From: [REDACTED]
Sent: 02 October 2026 08:09
To: Nicola Spencer
Subject: RE: Request for further information BN/107/26/NMA
Attachments: CHURCH LANE 05P REV A PROPOSED FLOOR PLANSI.pdf; CHURCH LANE 07 REV A ROOF PLANS.pdf; CHURCH LANE 06 REV D PROPOSED ELEVATIONS.pdf

FOR MR J. BOSCO BROWN		
SITE ANAND BHAWANI, CHURCH LANE, EASTERGATE. W. SUSSEX. PO20 3XD		
TITLE PROPOSED FIRST FLOOR ADDITION & ALTERATIONS GROUND & FIRST FLOOR PLANS		
SCALE 1:100 @ A3	DRAWN AH 11/23	DRAWING NO. 05P REV A

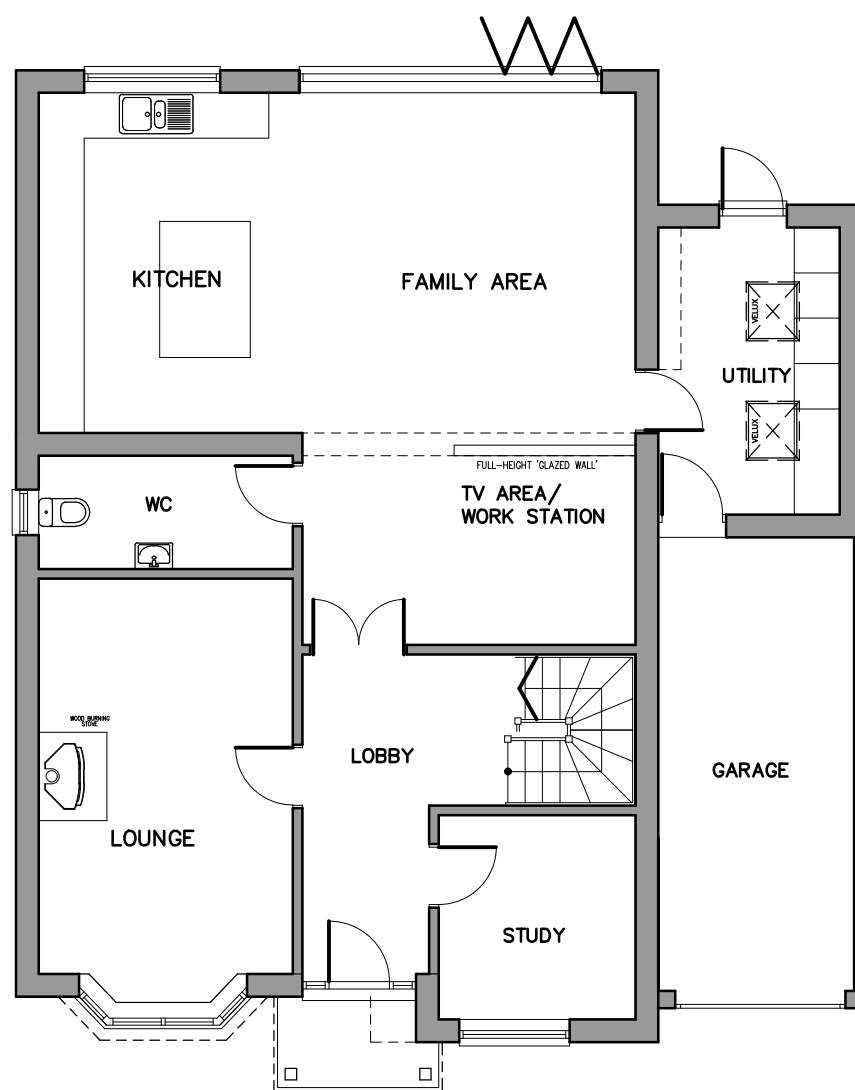
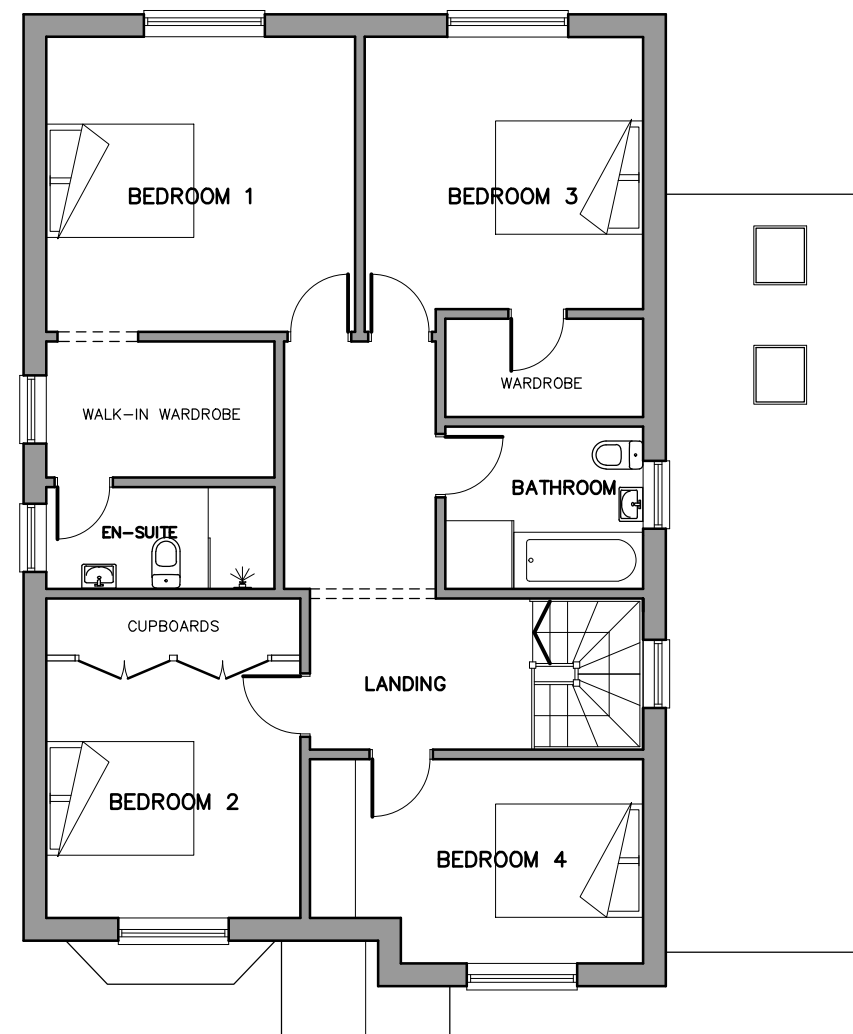
I have just checked the plans and the proposed elevations scales perfectly, but the roof plan and floor plan are still scaling incorrectly at 5.3 m. I am sorry could you have another look at them, whatever you did on the elevations worked.

The three PDFs were created in the same drawing with the same sheet size and scaling so I am hoping that I mistakenly sent you the older version of two of the drawings!
